**Application for a non-material amendment following a grant of planning permission,
Town and Country Planning Act 1990**

**Non material amendment to previous permission 2016/91501 for erection of first
floor side and rear extension, single storey rear extension and vehicular entrance
gates (within a Conservation Area)**

Braystone House, 32a, Wilshaw Road, Meltham, Holmfirth, HD9 4DZ

Application Number: 2016/93572

section b - b

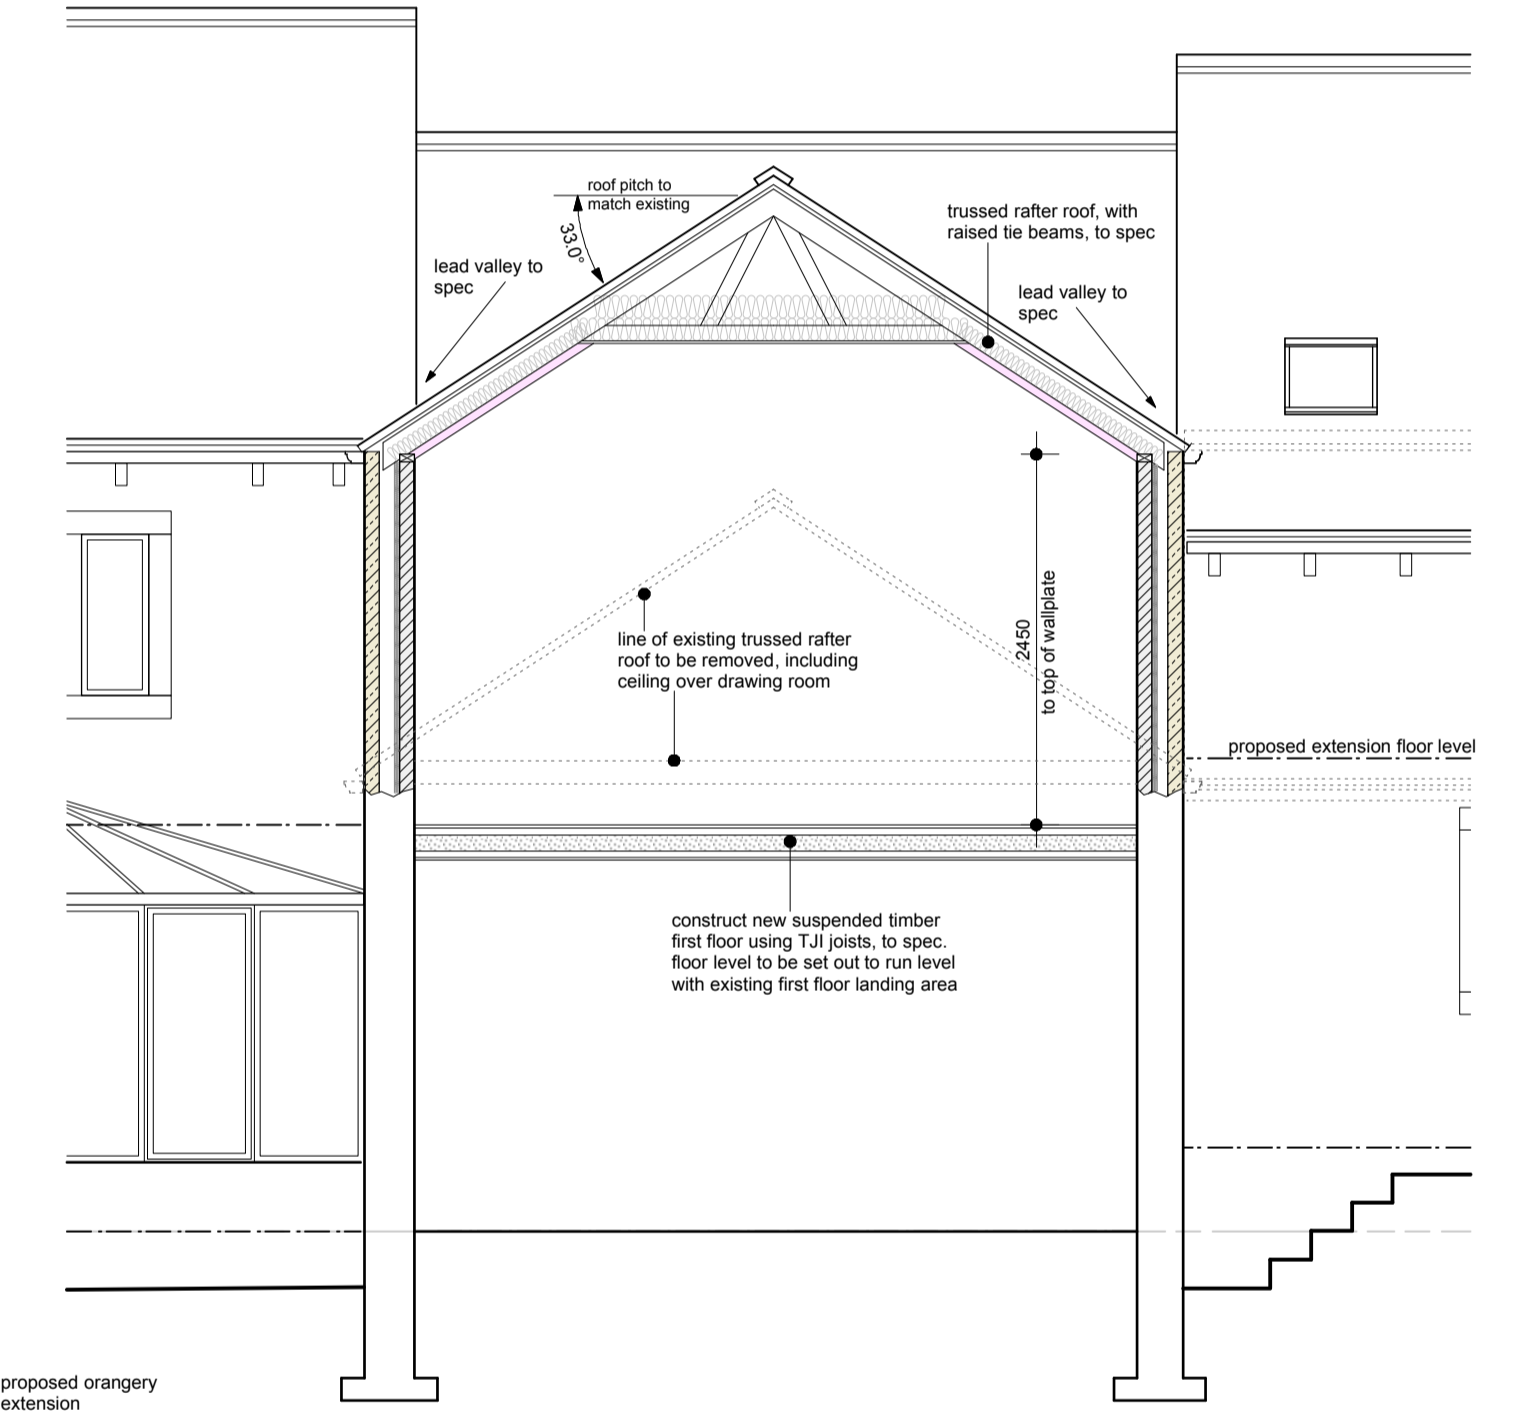
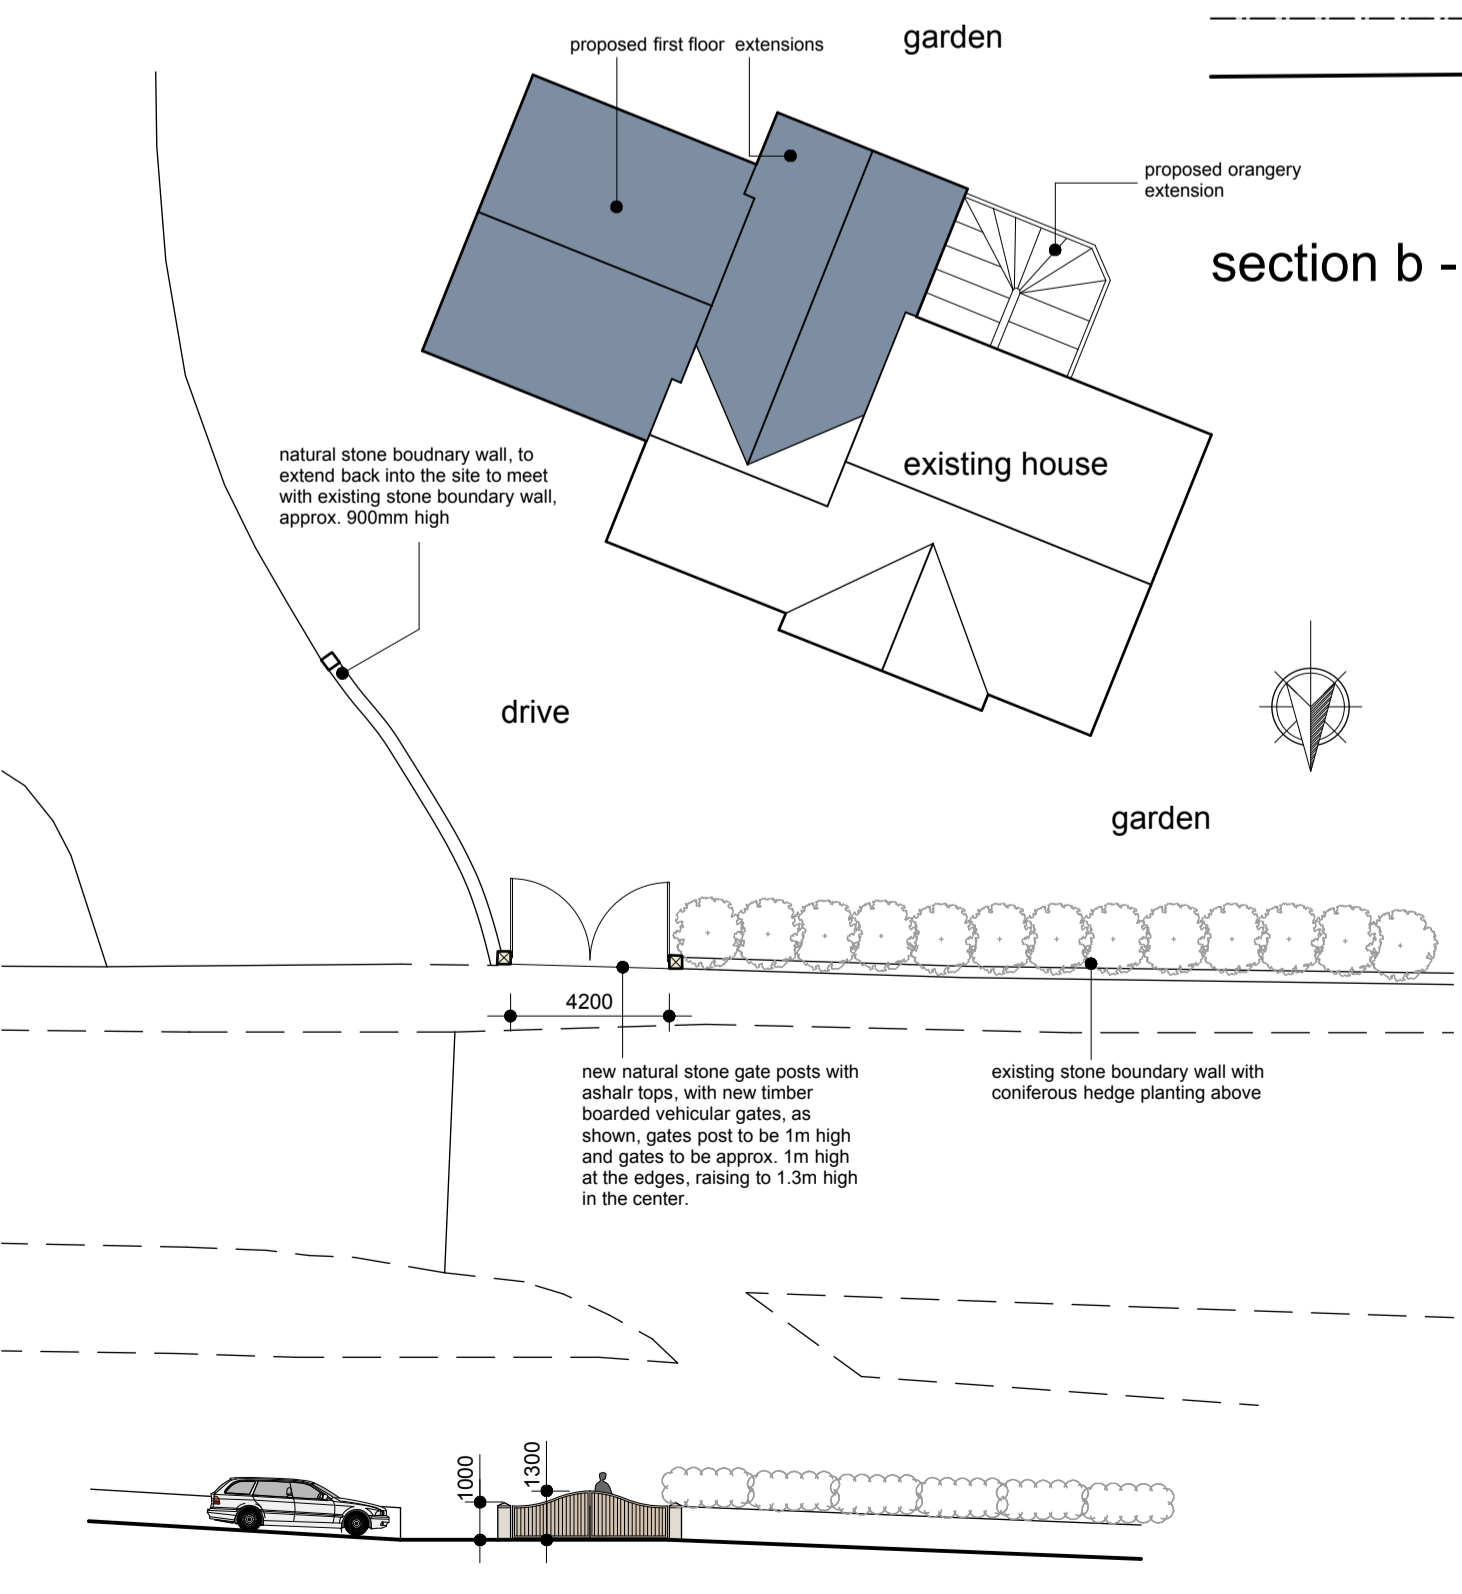
Thank you for your application dated 21-Oct-2016 for a non-material amendment to the above scheme. The amendment sought is to increase the height to ridge and eaves height of the side extension as indicated on drawing no.16026D-05-P01 titled "plans & sections as proposed" and drawing no. 16026D-06-P01 titled "elevations & specification as proposed" received by the Local Planning Authority on 25 October 2016.

I confirm that the alterations are acceptable and may be considered as a non-material amendment to the approved drawings. It should be noted that this letter relates only to the non-material amendment sought and it is not a re-issue of the original planning permission. The two documents should be read together and as such, all conditions imposed on the original granting of planning permission apply to the proposal as now amended. A copy of this letter and the amended plans will be retained on the public record of approved documents.
